Review of Response to Council Submission

80-88 Regent Street, Redfern – SSD 7080

City of Sydney

Attach 3 - Response to Issues CoS

Job No.	Drawing No.	Revision
5359	DA-0502	/ 6

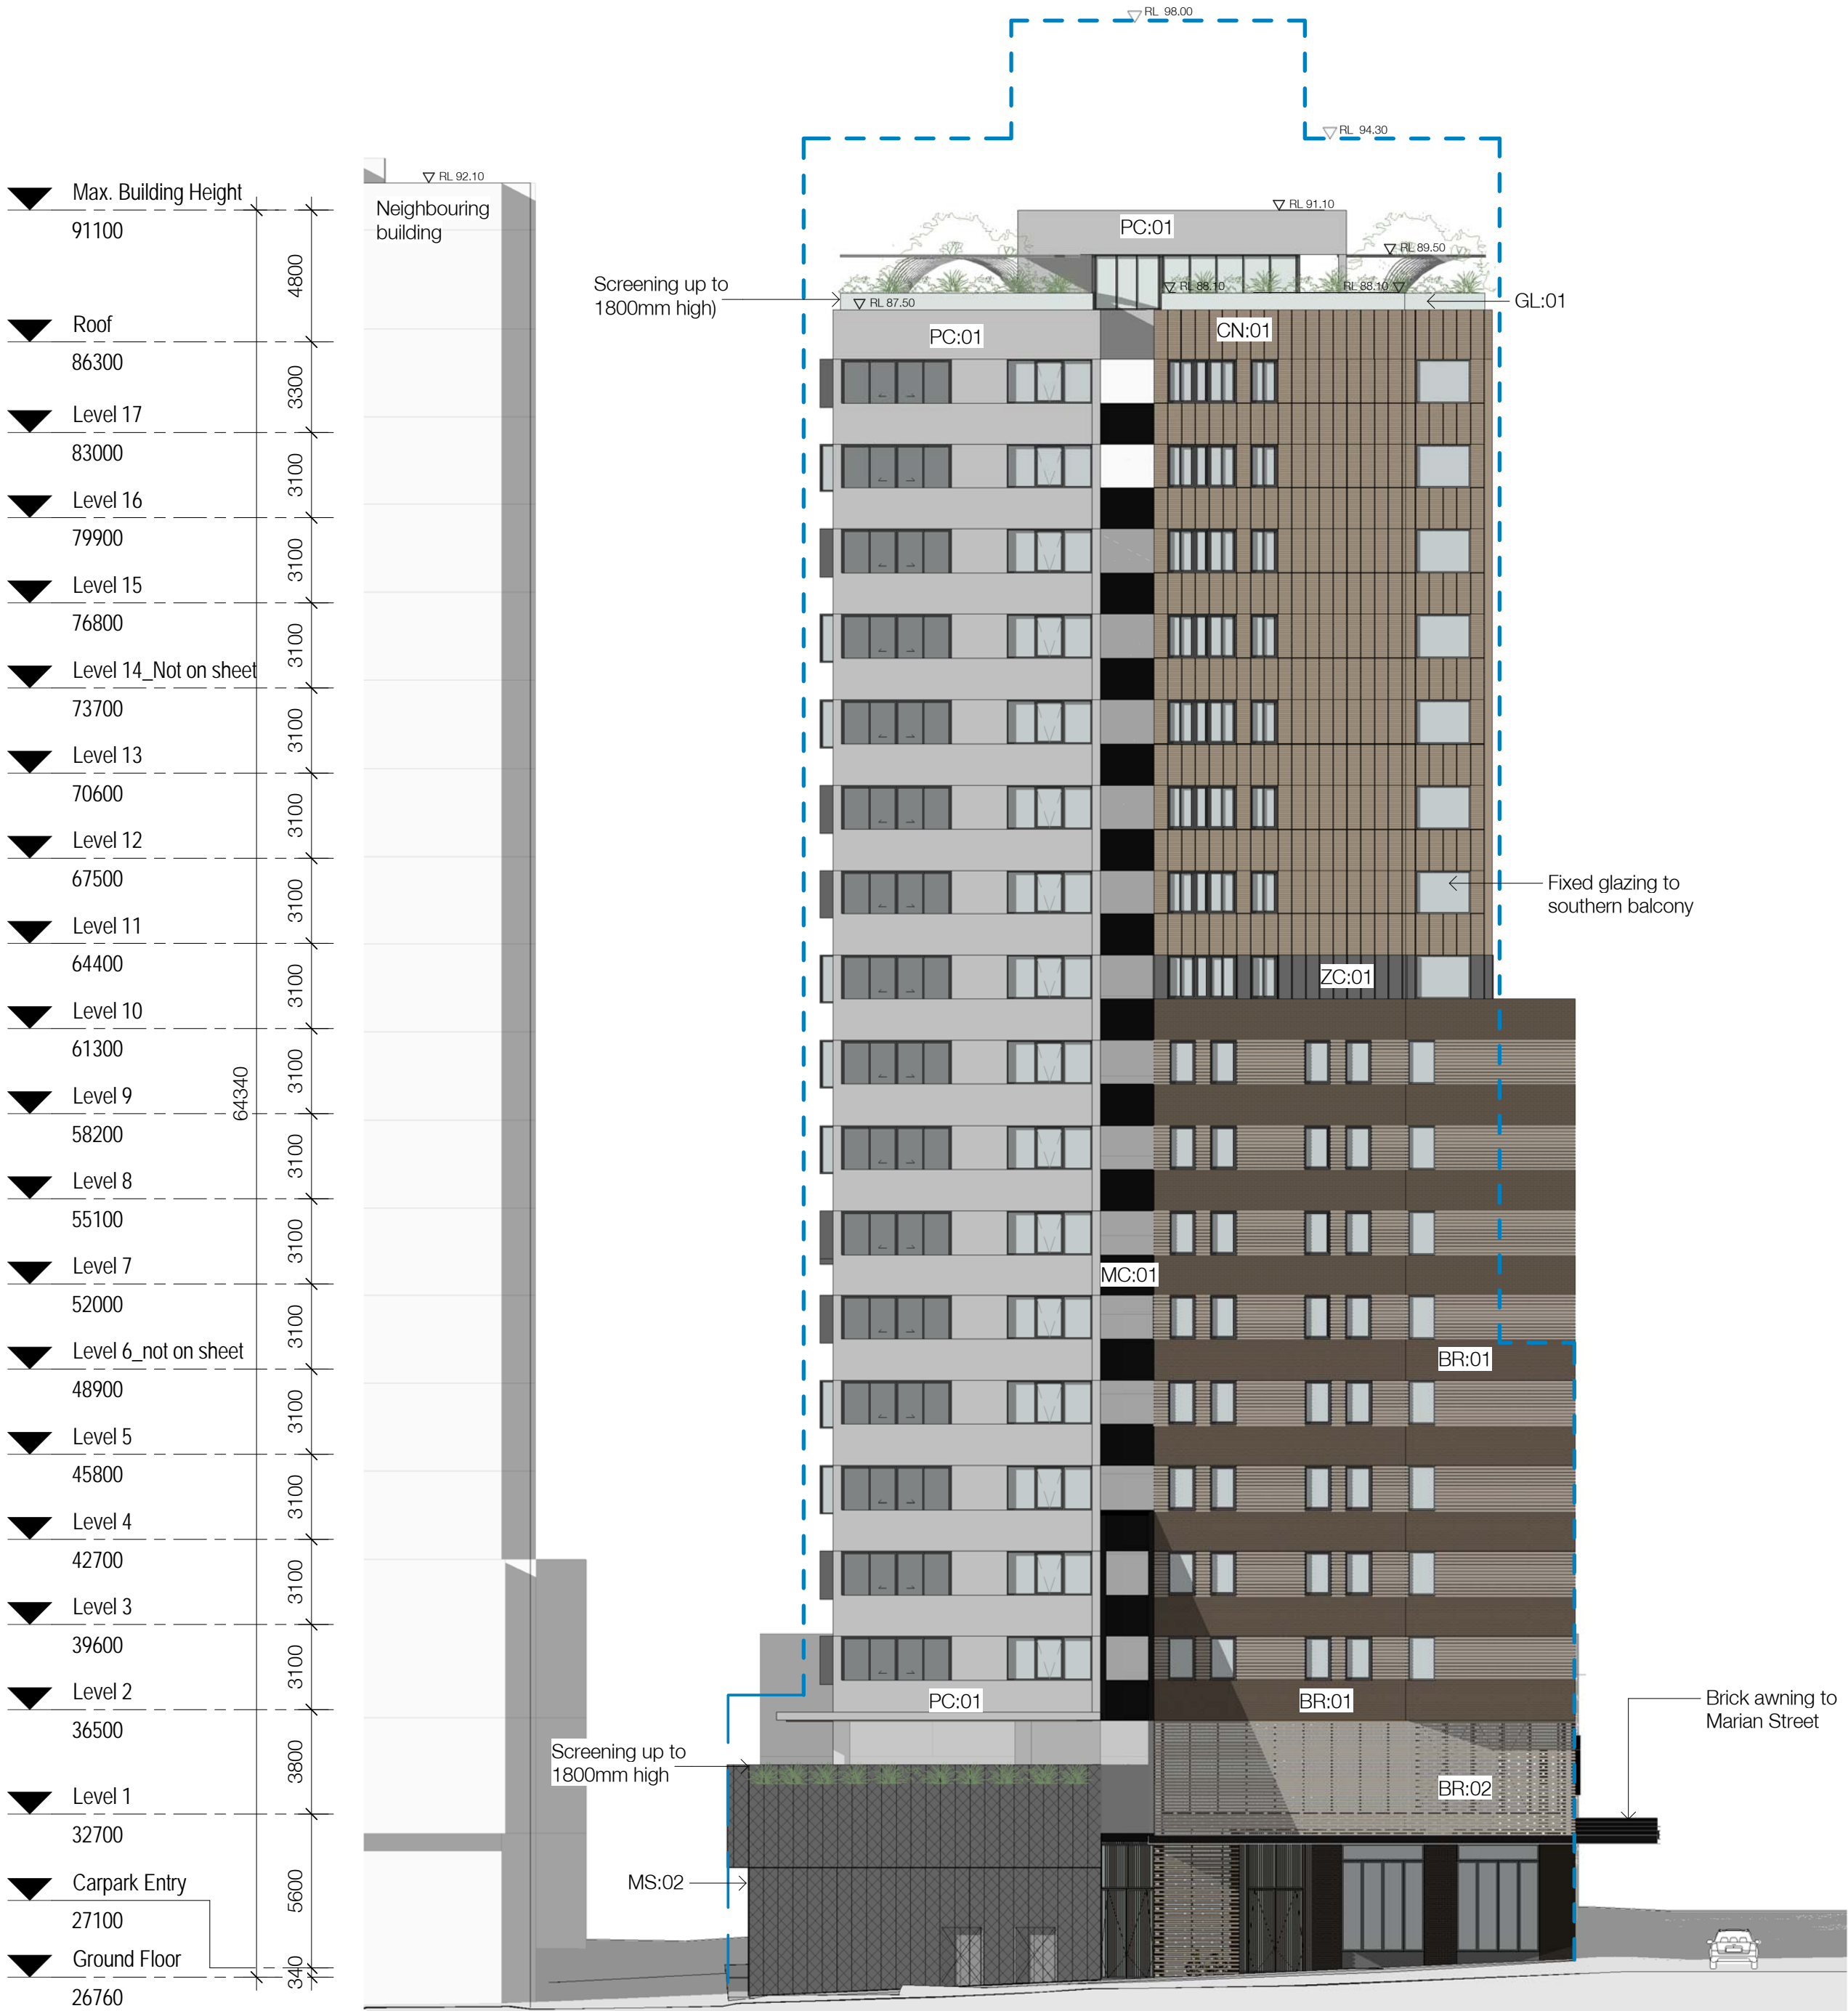
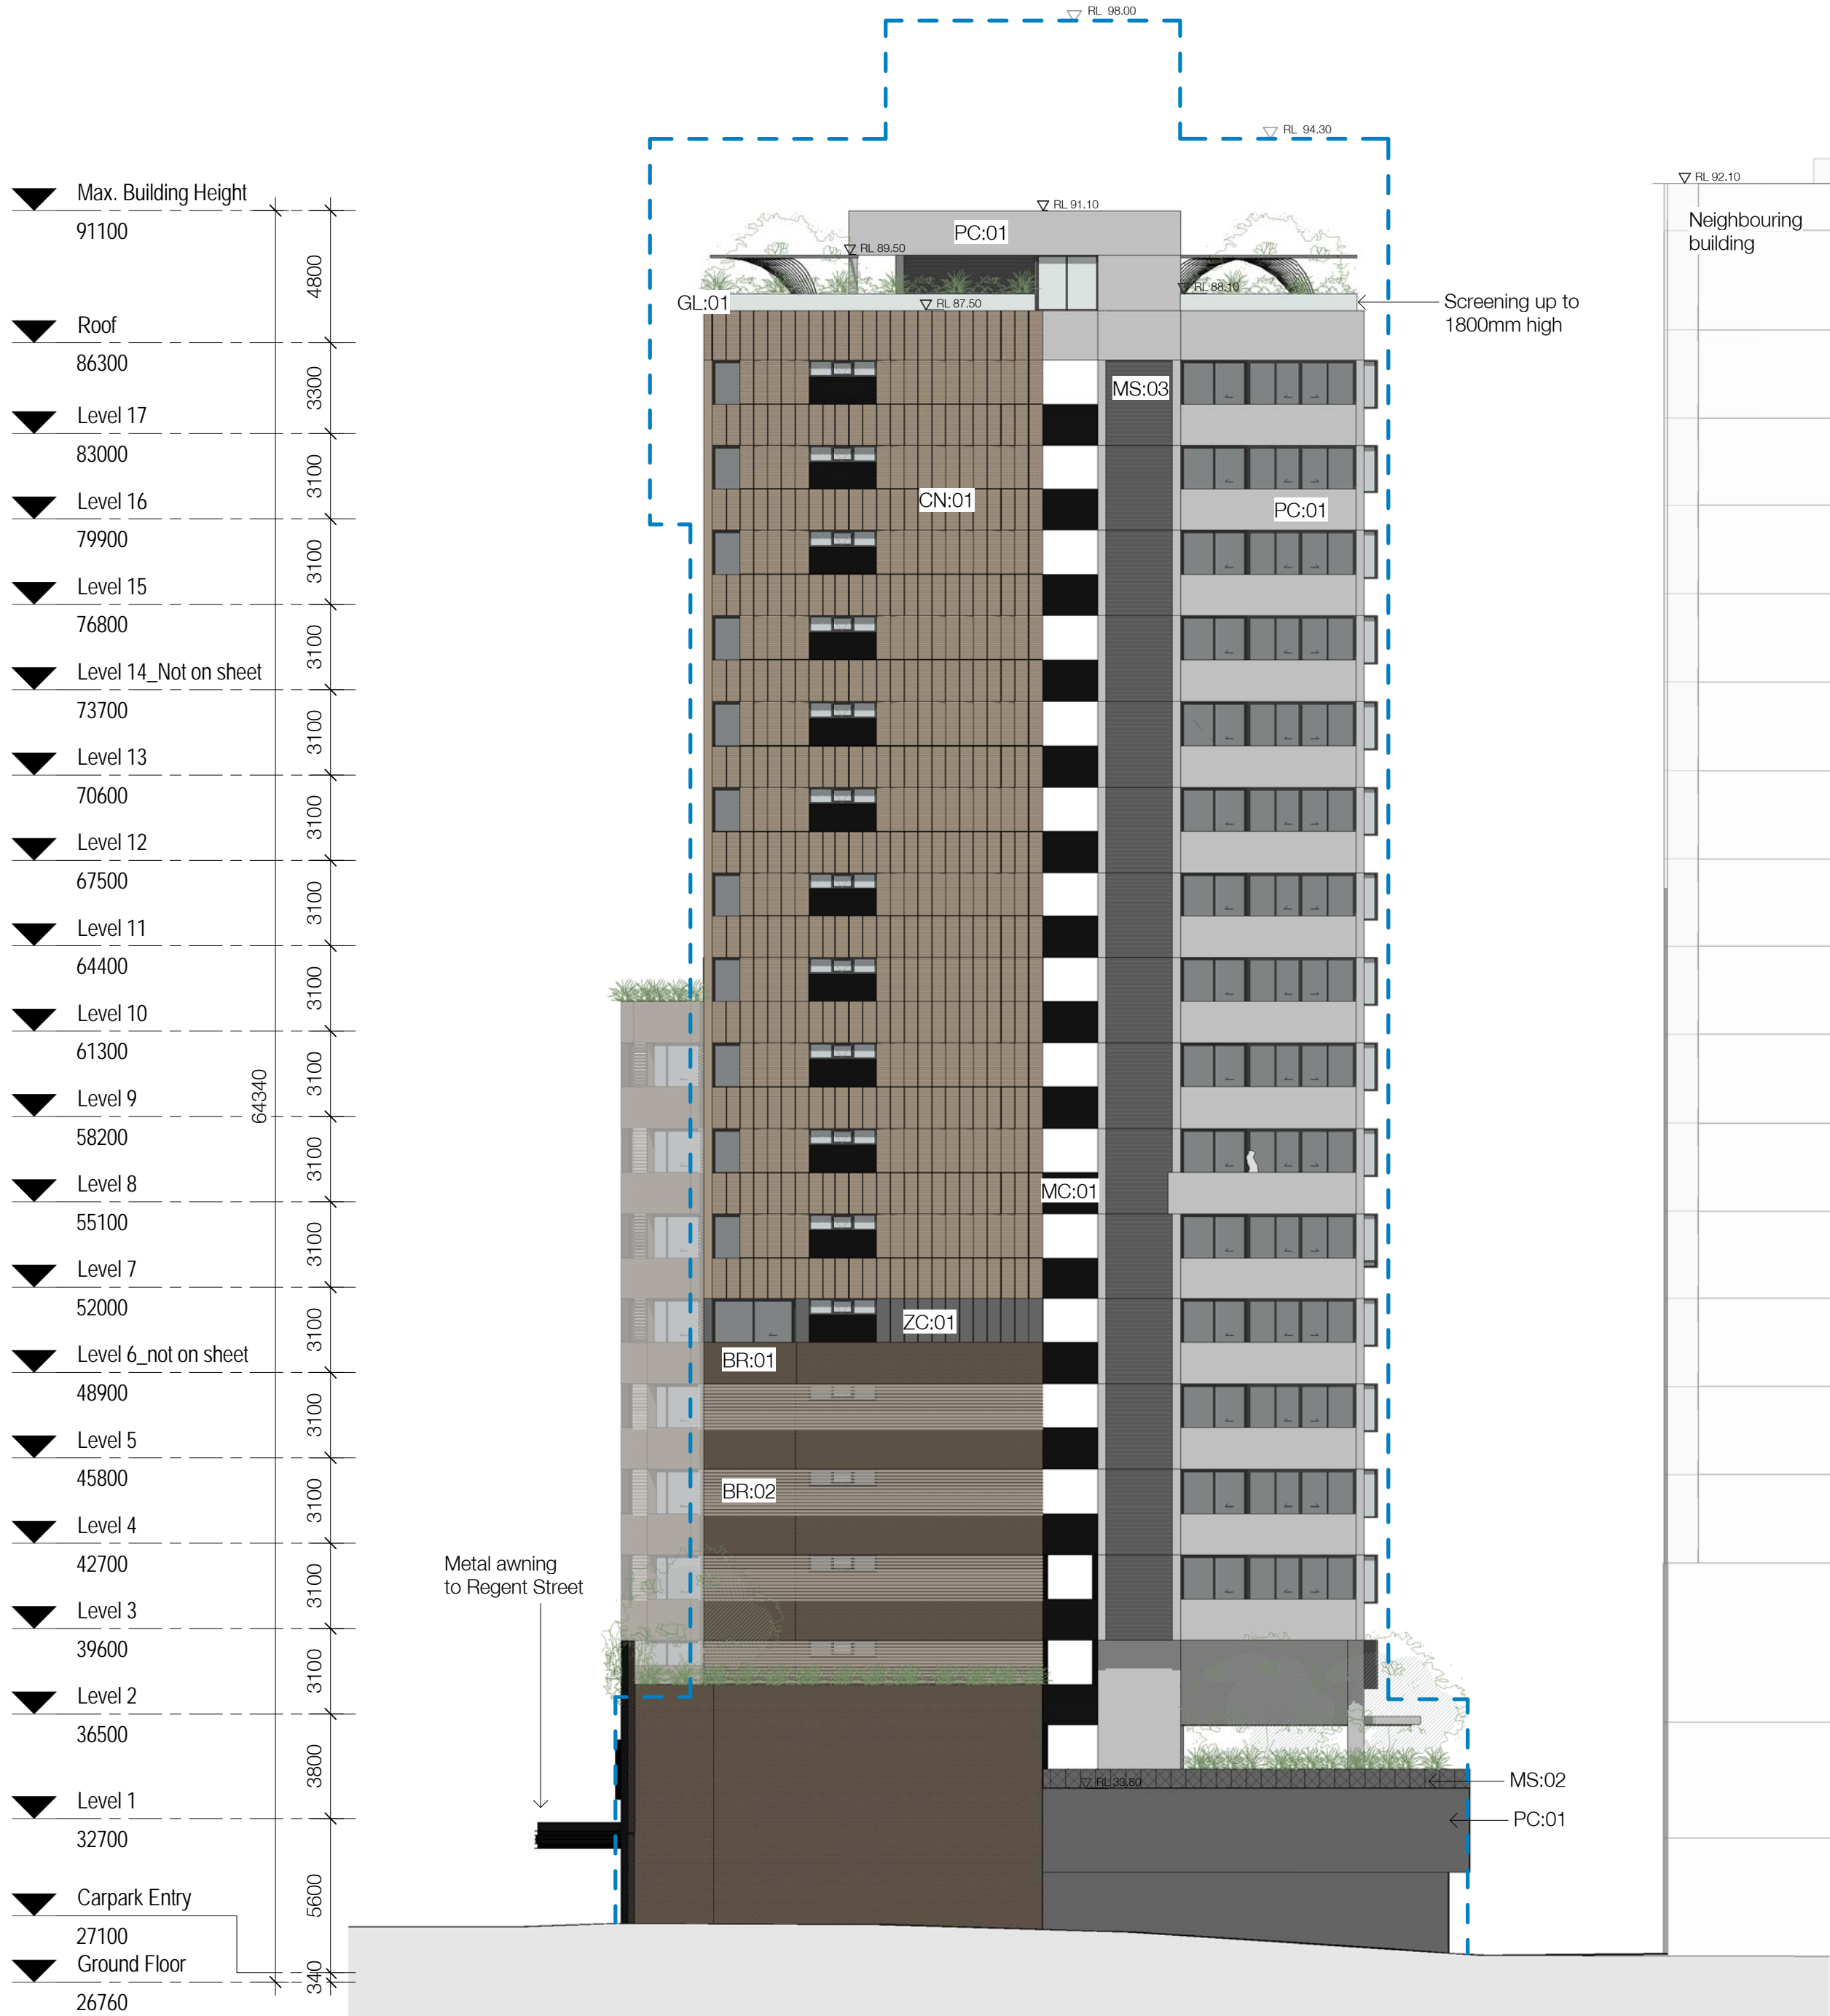
23. Building expression		<p>The vertical (triangular) part of the awning located on Marian Street is not shown in plan. The elevations DA0502 have a brick awning annotated to Marian Street and a metal awning to Regent Street. The photomontages show the same treatment for the awning wrapping around the corner of the building. Clarity is required with regard to what is actually proposed.</p> <p>The building expression has been maintained over the duration of the process and has been refined to respond to our comments. As mentioned above, it is the detail and co-ordination that is being sought in these comments.</p> <p>It will be important that the proposal maintains its intent of the building expression through the construction process. Due to the 'tight fit' of the 4 towers on this block, materiality and finishes will play an enormous role in distinguishing each tower. If the materials, finishes and colour of the towers are too similar this could result in all the cumulative surfaces of the 4 towers being read as one mass due to the lack of negative space between each tower form.</p>	Architectural drawings and visualisations have been updated to provide further detail of the building expression.	Refer to Attachment 1.
